Re: Santa Fe Tow Lot #13

8101 Jacs Ln., NE

**Traffic Circulation Layout**

Engineer's/Architect's Stamp dated 6-21-16 (D16-D002A5)

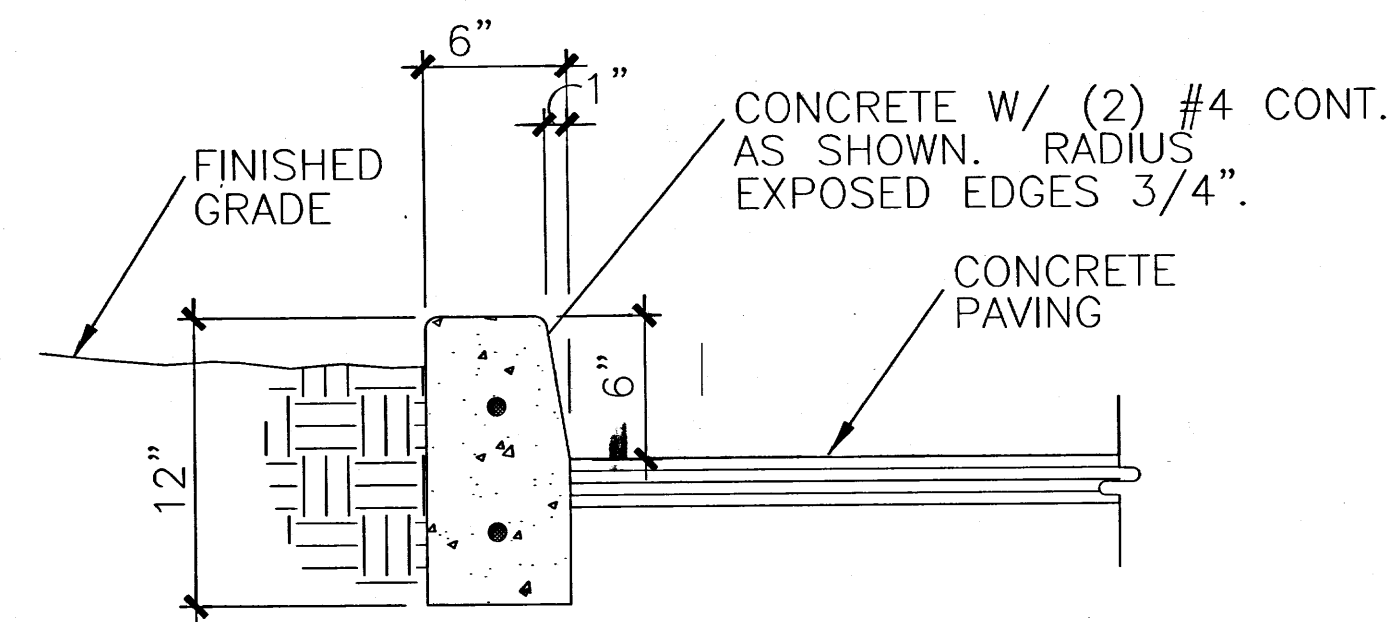
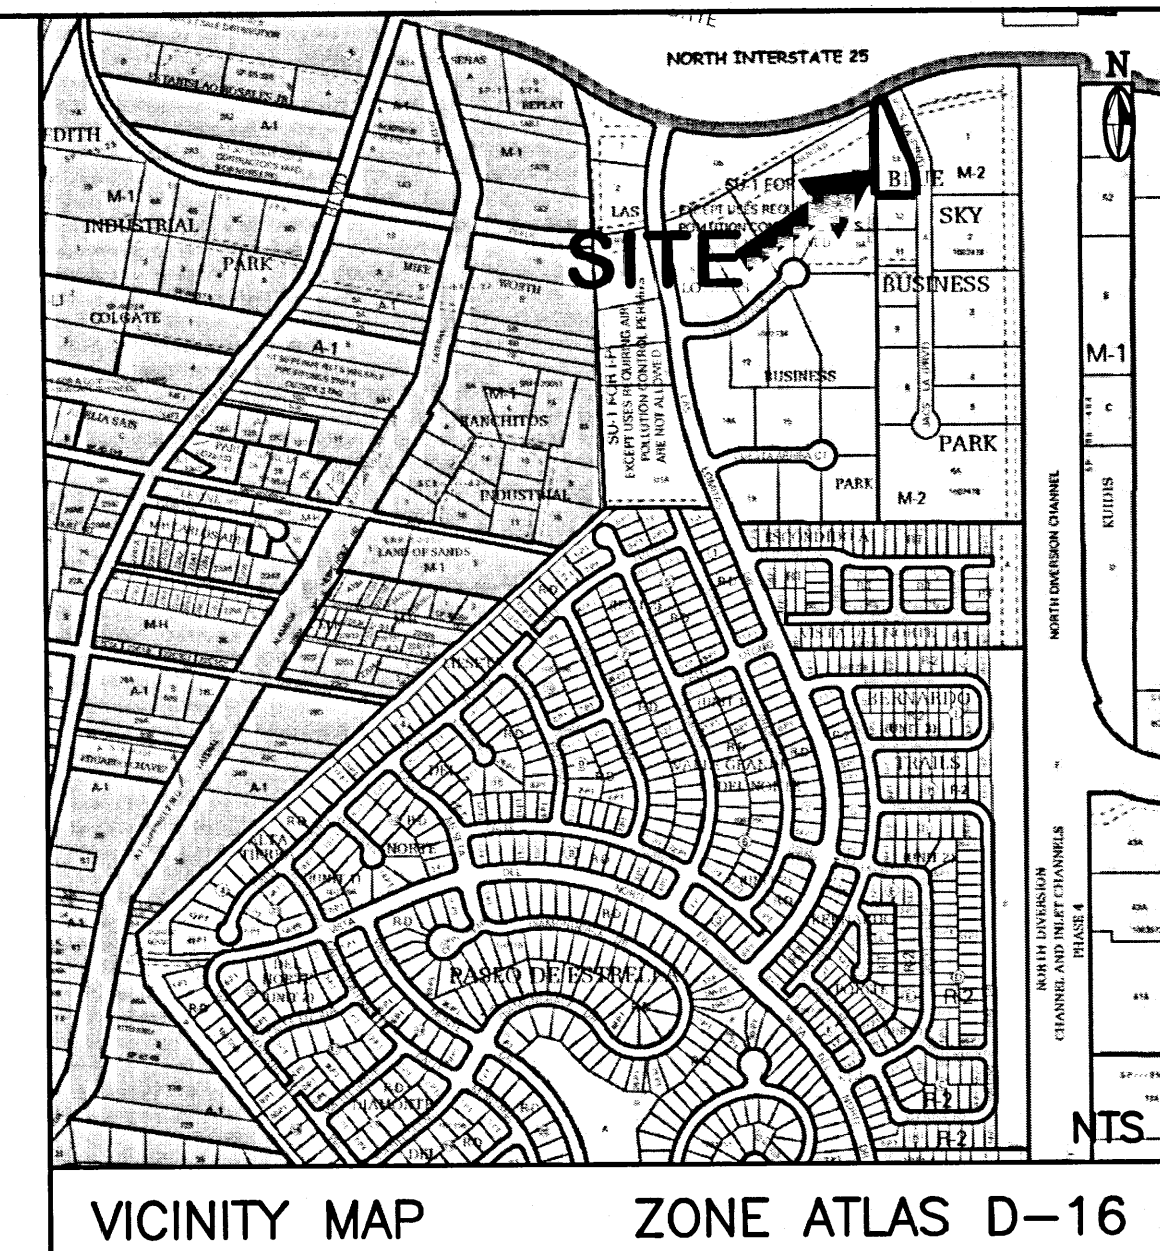
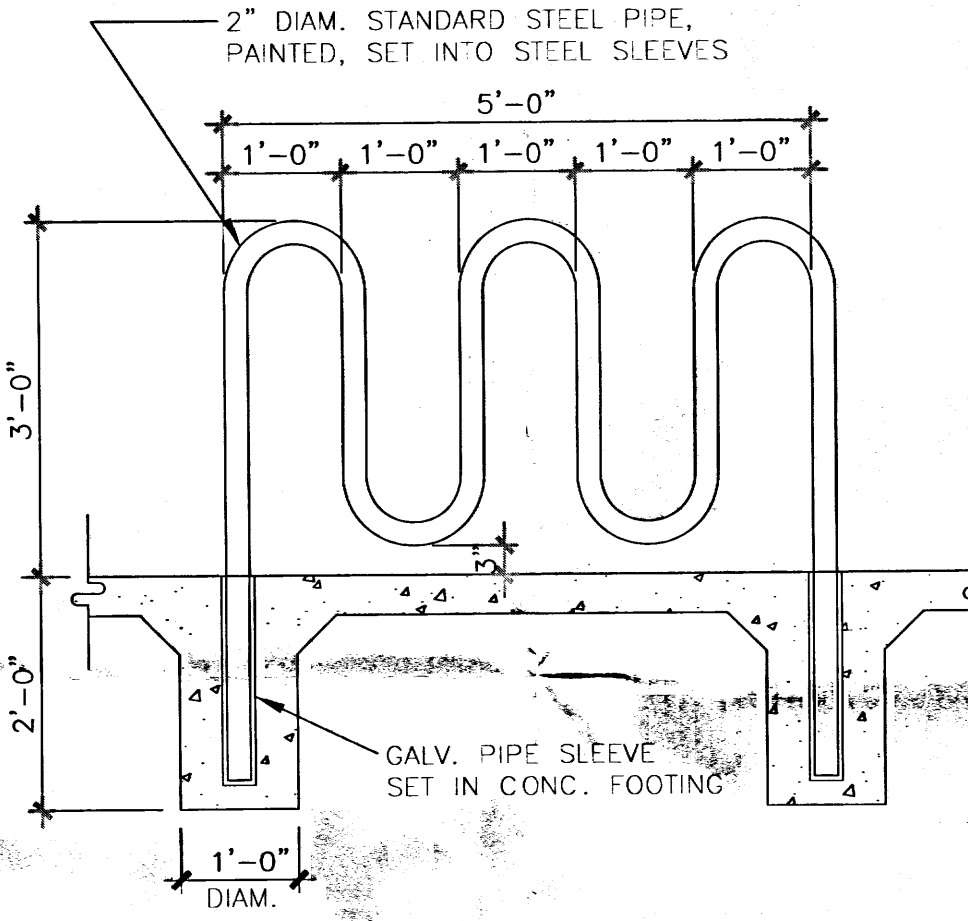
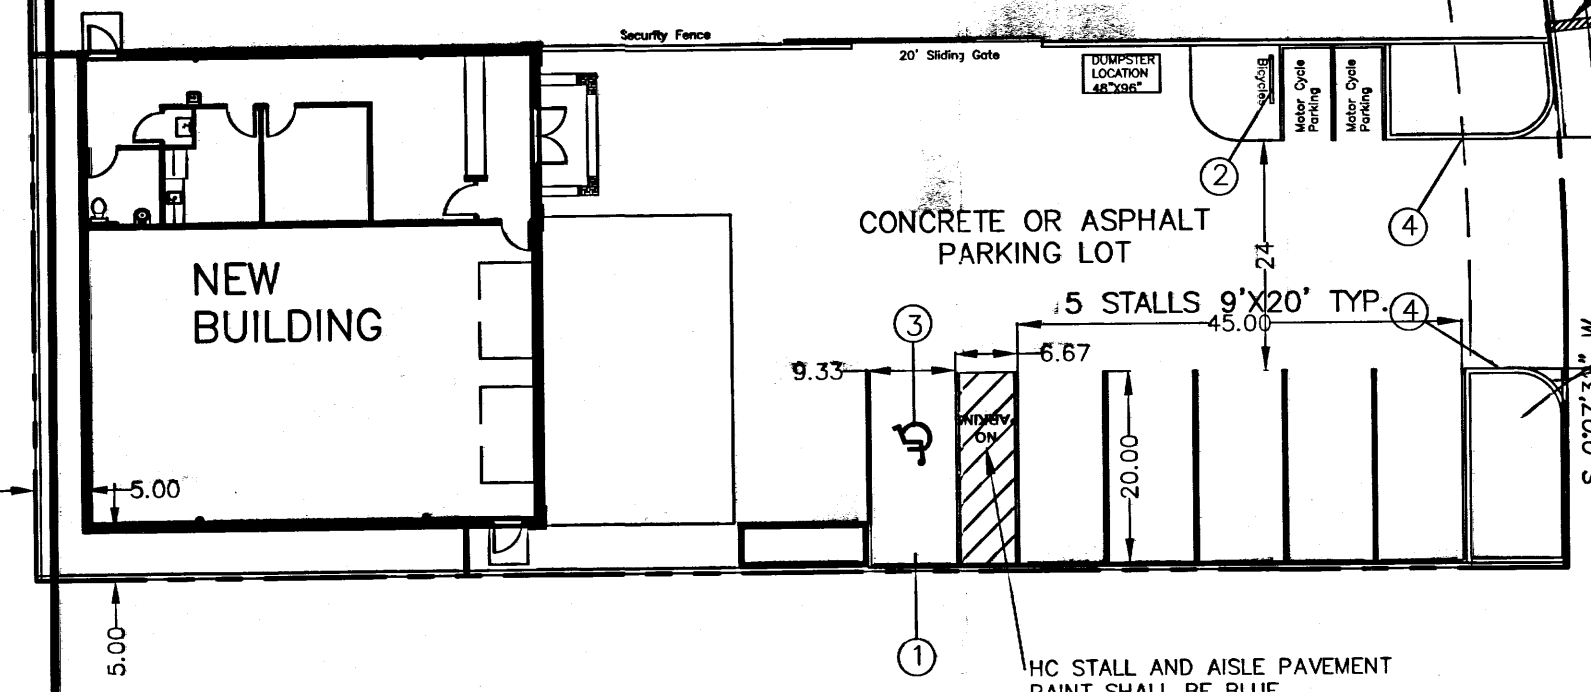
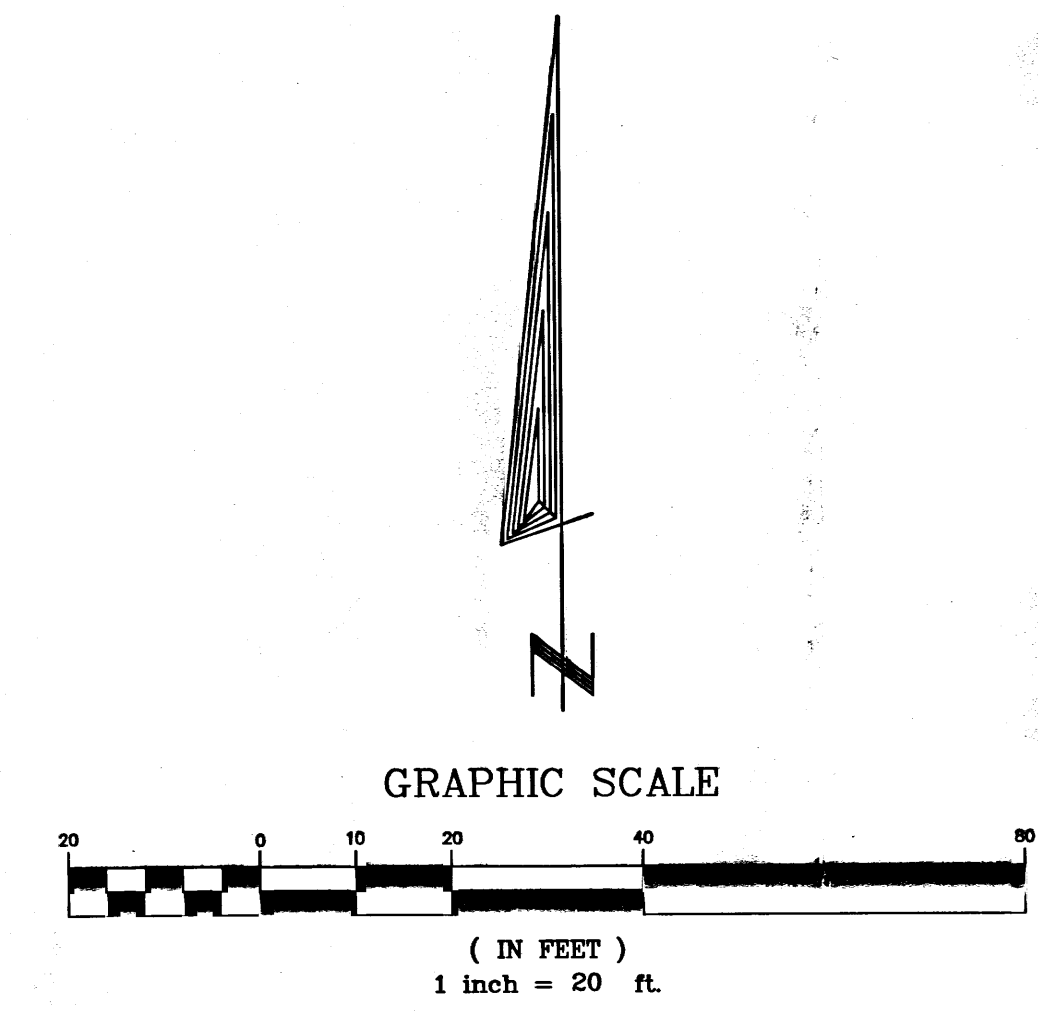
- 1. Please identify all existing buildings, doors, sidewalks, curbs, drive pads, walls and anything that influences the parking and circulation on the site.
- 2. Show all drive aisle widths and radii.

- 3. Please detail the width of the proposed drive pad.
- 4. Please detail the ADA ramps and sidewalk from the Public R.O.W.

5. Per the DPM, a 6 ft. wide ADA accessible pedestrian pathway is required from the public sidewalk to the building entrances. Please clearly show this pathway and provide details.

- 6. Per the DPM, a 6 ft. wide ADA accessible pedestrian pathway is required from the HC parking stall access aisles to the building entrances. Please clearly show this pathway.
- 7. Provide a min 6" or max 8" high concrete barrier curb or other acceptable barrier between landscaping and parking areas and/or drive aisles.
- 8. Design delivery vehicle route needs to be shown.
- Service vehicle and/or refuse vehicle maneuvering must be contained on-site; provide a copy of refuse approval.

10. Please provide a sight distance exhibit (see the *Development Process Manual*, *Chapter 23, Section 3, Part D.5 Intersection Sight Distance*). Please show this detail for the entrance/exit on Jacs Ln.

- 11. Please add the following note to the clear sight triangle: "Landscaping and signage will not interfere with clear sight requirements. Therefore, signs, walls, trees, and shrubbery between 3 and 8 feet tall (as measured from the gutter pan) will not be acceptable in this area."
- 12. Please include two copies of the traffic circulation layout at the next submittal.
